**2021 No. 535**

**The Rampion Offshore Wind Farm (Amendment) Order 2021**

Footpath diversion consented under The
Rampion Offshore Wind Farm Order 2014

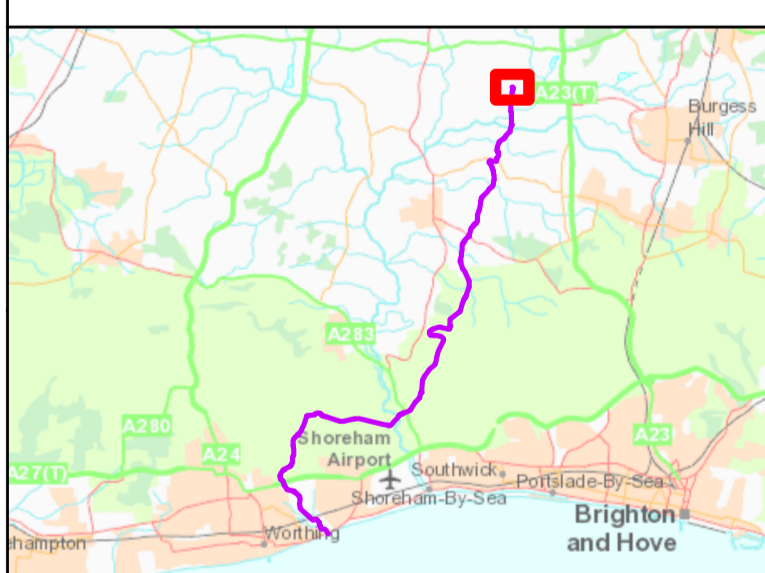
- (i) for “453 metres” substitute “186 metres”;
- (ii) for “vertical zebra stripes” substitute “black and white dashes”; and
- (iii) for “A and E on the” substitute “A and B on the revised”;

- (i) for “736 metres” substitute “218 metres”;
- (ii) for “black” substitute “solid orange”; and
- (iii) for “A, B, C, D and E on the” substitute “A and B on the revised”.

““revised footpath stopping up and diversion plan” means the plan dated 14 October 2020 and certified as the revised footpath stopping up and diversion plan by the Secretary of State for the purposes of this Order;”.
